Recommendation Report for Planning Permission for Works or Extension to a Dwelling

REF NO: LU/343/21/HH

LOCATION: 2 Fairway
Littlehampton
BN17 6PY

PROPOSAL: Part demolition of garage, single storey side extension and pitched roof to match existing house

Drawing Title
GENERAL ARRANGEMENT
AS PROPOSED

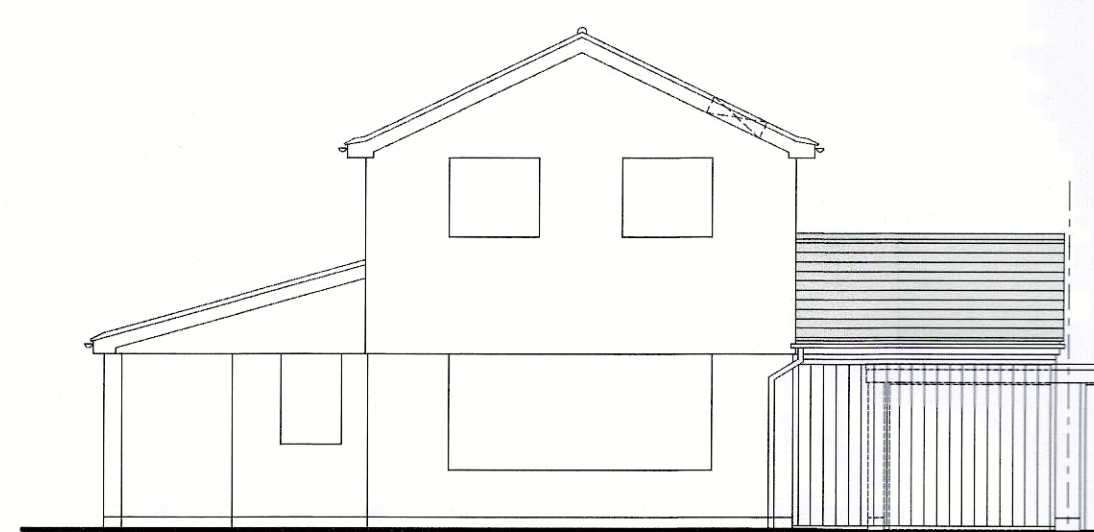
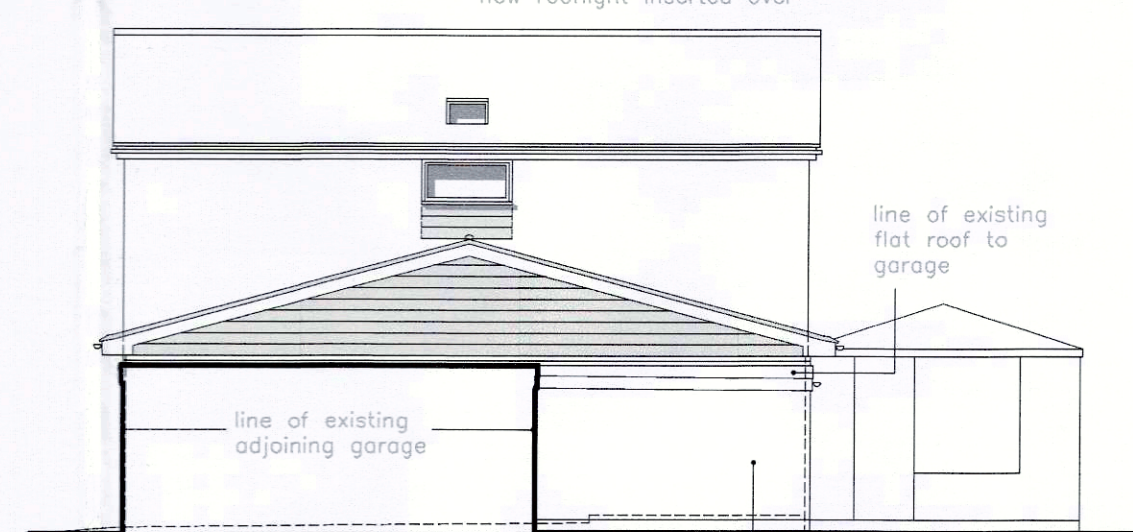
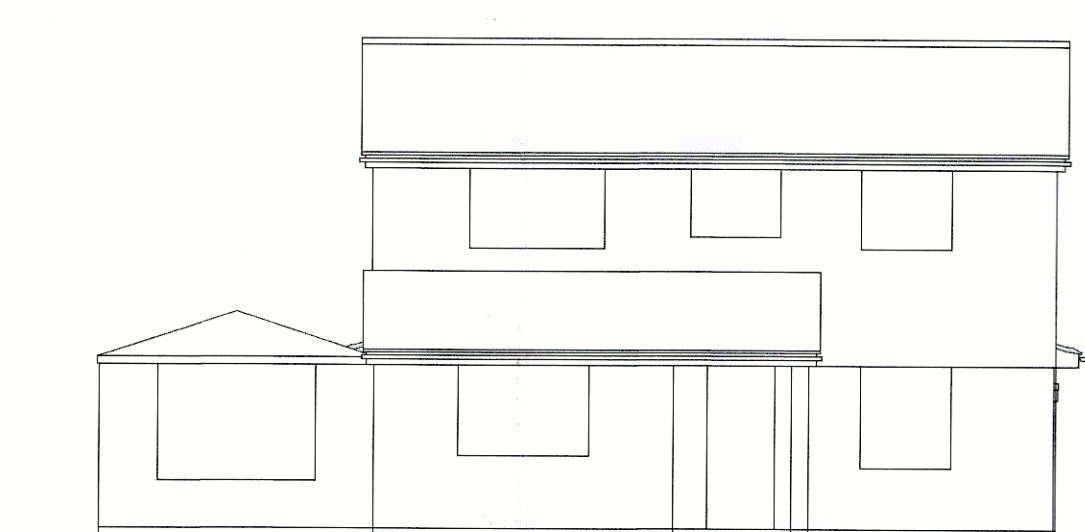
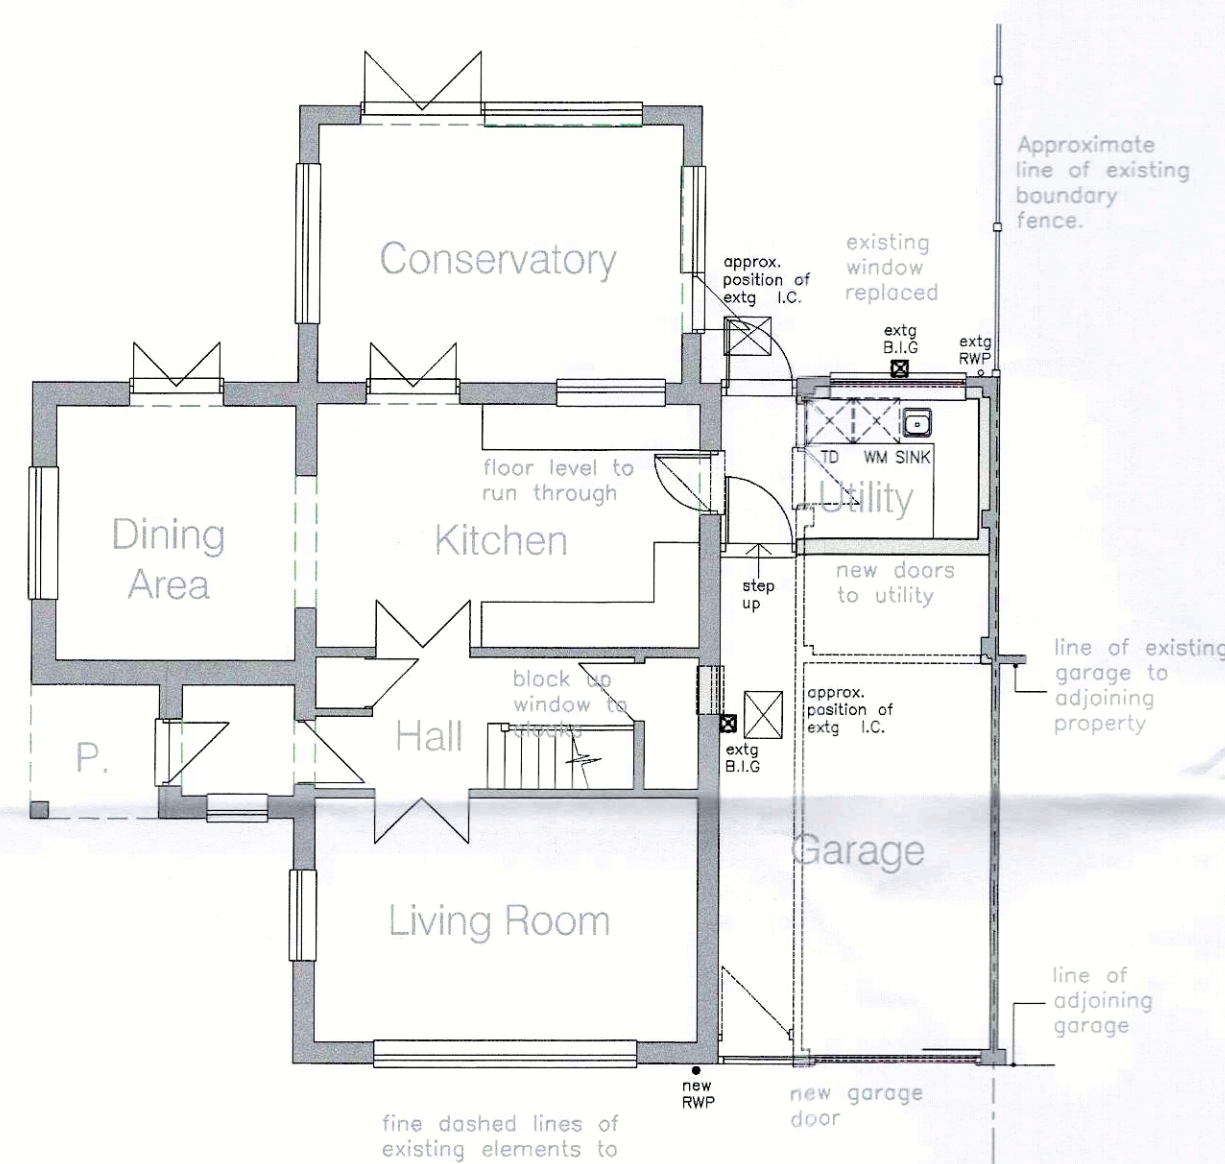
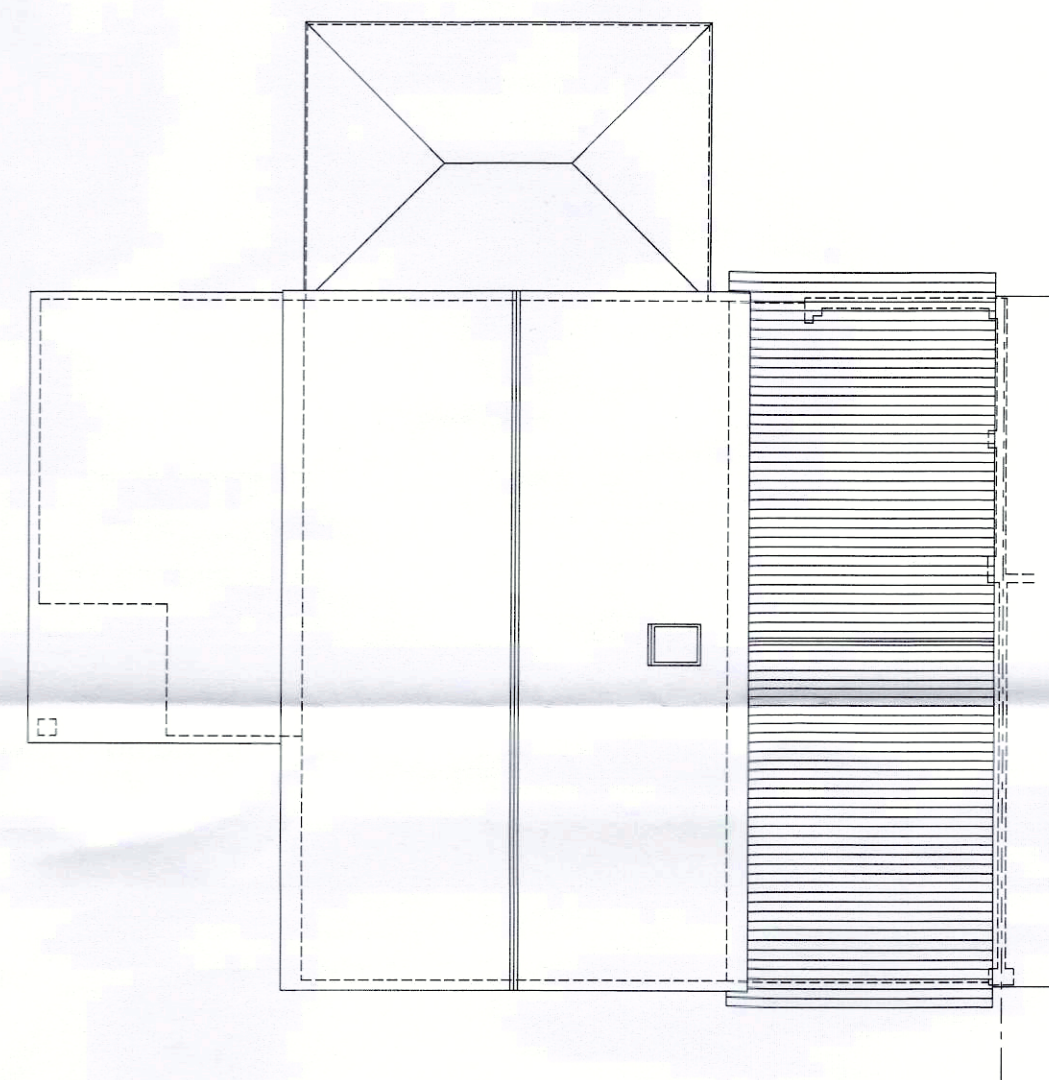
The extension is located to the side of the site and is visible from the street scene. The roof rises up from the front of the dwellinghouse to a pitched roof ridge. The new extension would fill the entire space between the house and the side boundary. The neighbouring property, 44 Tideway, has a garage running along the boundary adjacent to the proposed extension.

The roof would be pitched and the height of the pitched roof would be 3.6 metres with a length of 9.06 metres. It is considered that the siting, scale and design of the proposed extension is such it would be a subservient and well integrated addition.

Section M of the Design Guide states 'Extensions should respond to and complement the existing character and appearance of the building and wider townscape in terms of scale, massing, materials, openings and roof form.' The proposal complies with the design guide being of appropriate scale to the host dwelling.

The extension will have a depth of 3.6 m, a length of 9.04 metres with a height to pitched roof ridge of 3.7 metres. This would face the side elevation of the neighbouring property 44 Tideway, which does not have any primary habitable windows in it and is therefore considered to have an acceptable impact.

The extension will not have any side facing windows in it and therefore due to its siting and with it being single storey in nature is not considered to result in adverse overlooking.
